National Grid submitted Document 8.4.12.2, *Response to ISH2 Action Point 27 – Masterplans* (Planning Inspectorate Reference EN020027), in June 2026. Despite being a recent submission, the document contains significant inaccuracies.

Great and Little

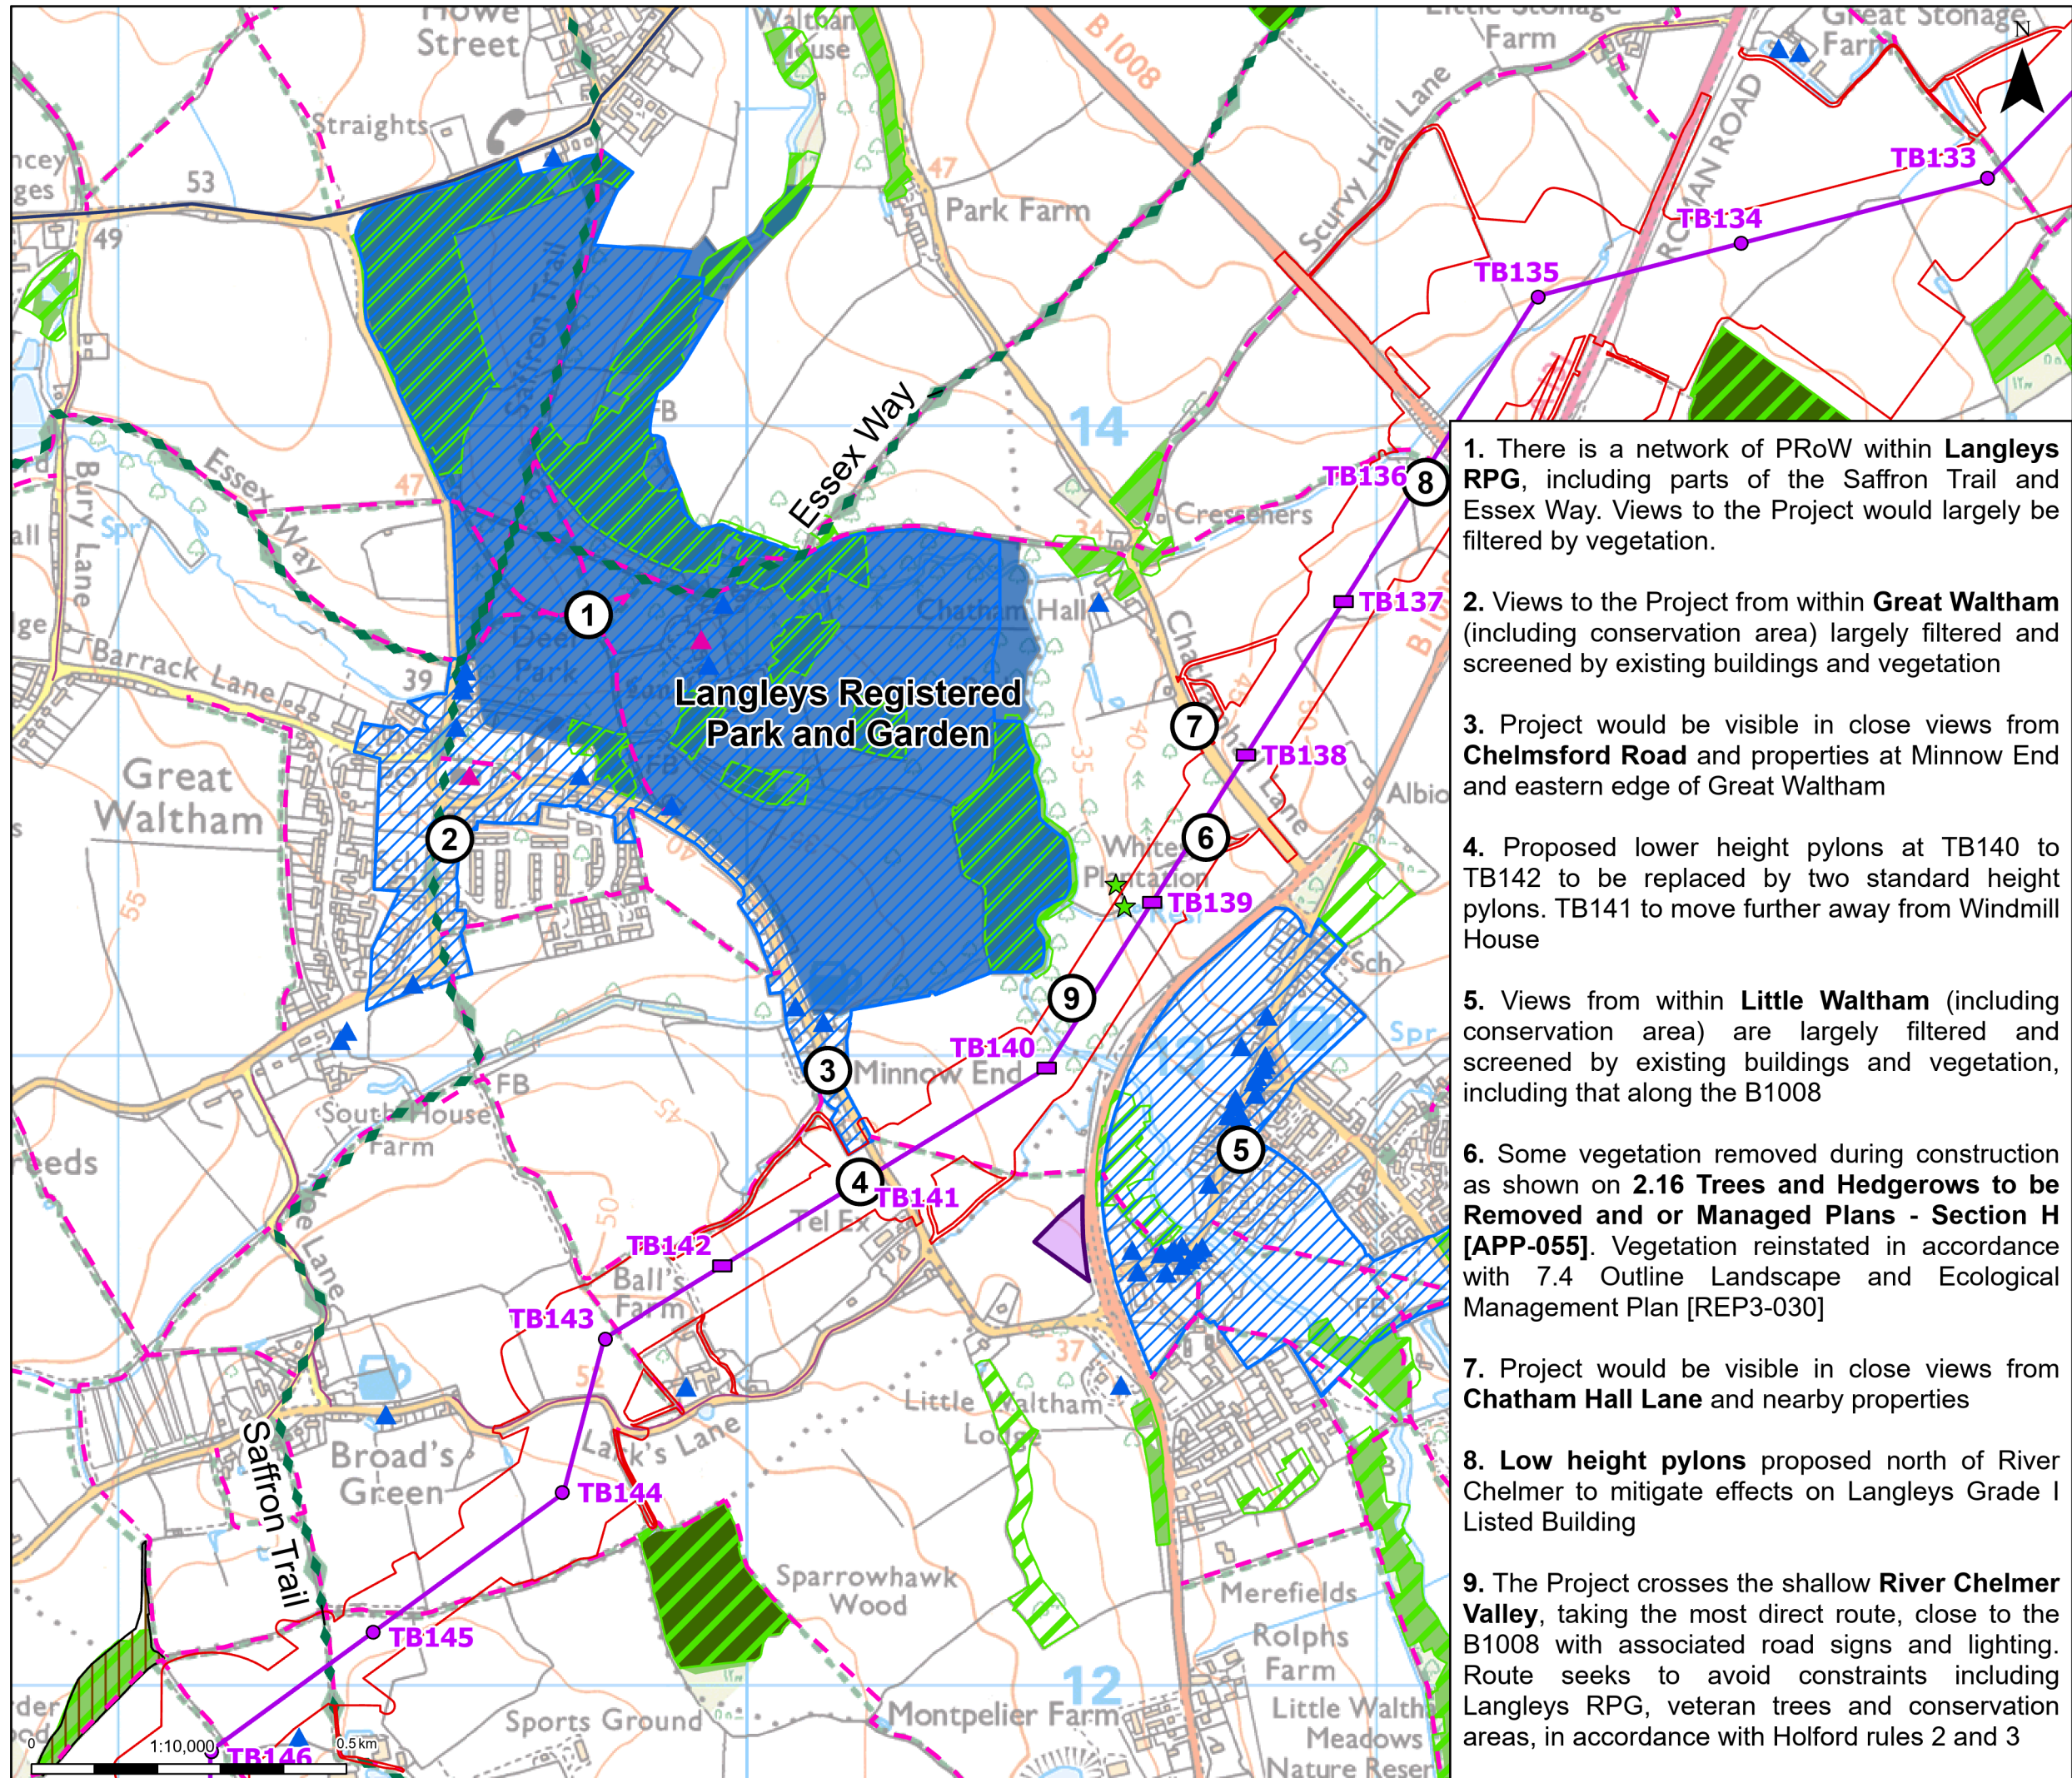
We have been informed directly by National Grid that the pylon route between TB137 and TB143 has been altered. However, this document continues to show low-height pylons to the south of the River Chelmer. At this advanced stage of the Examination, it is entirely reasonable for affected landowners to expect accurate plans. The continued publication of incorrect mapping makes it extremely difficult to understand the proposals affecting our land and undermines confidence in the information being provided.

Action Point 27: Great and Little Waltham – Draft Opportunities Plan

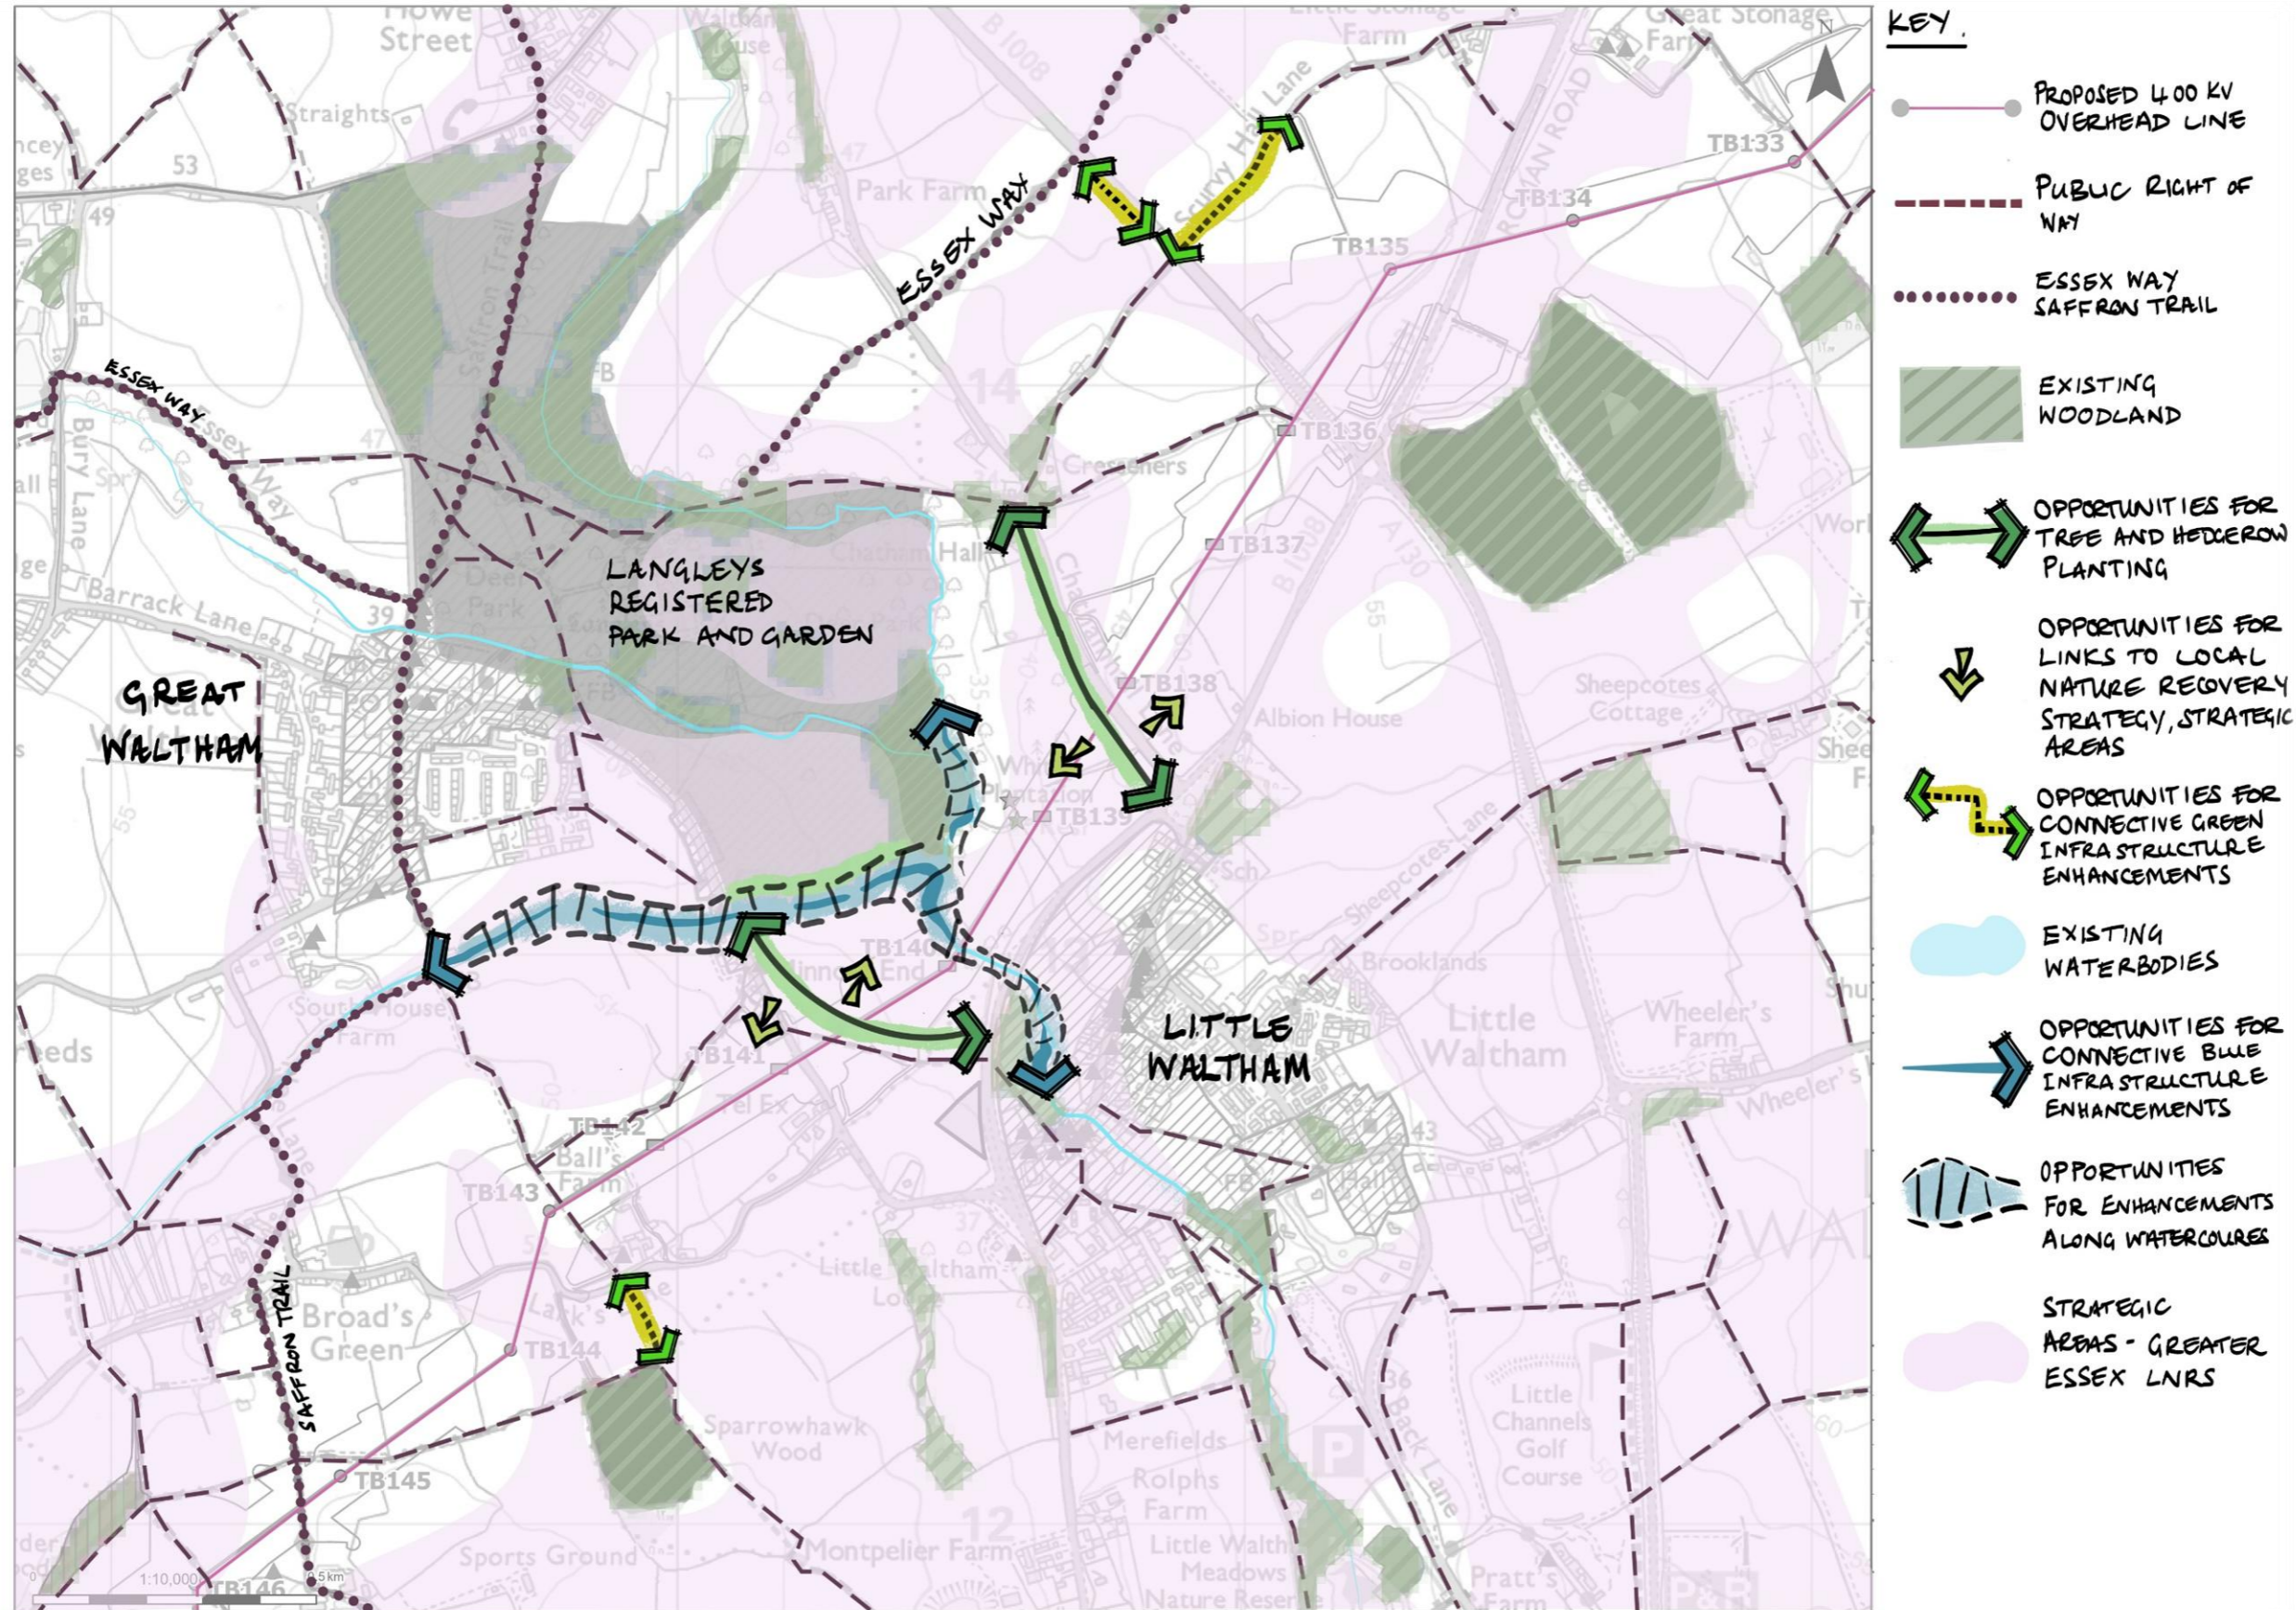
In Appendix F (page 28), *Action Point 27: Great and Little Waltham – Draft Opportunities Plan*, National Grid identifies "opportunities for enhancements along watercourses". One of the proposed areas lies within woodland, while the other two are existing Cricket Bat Willow plantations. National Grid has been informed on several occasions that these willows are a valuable commercial crop forming part of the Estate's farming business, yet this appears to have been disregarded.

The document also proposes planting trees and hedgerows across an active agricultural field. Such planting would divide the field into smaller parcels, making efficient commercial farming impractical. A further proposed planting opportunity is along Chatham Hall Lane, even though, with the exception of approximately 60 metres, the lane is already bordered by mature trees and hedgerows.

Meaningful engagement with those who know and manage the land would have avoided many of these inaccuracies and resulted in far more realistic and credible proposals, eg on the same plan there are three fields of permanent pasture where hedgerows would have been a beneficial suggestion. These fields can easily be seen on Google Maps, as can the hedgerows and trees down Chatham Hall Lane and the wood. This document was written to answer Action Point 27 from the EA, but in my view for Great and Little Waltham it fails to do so on many points.
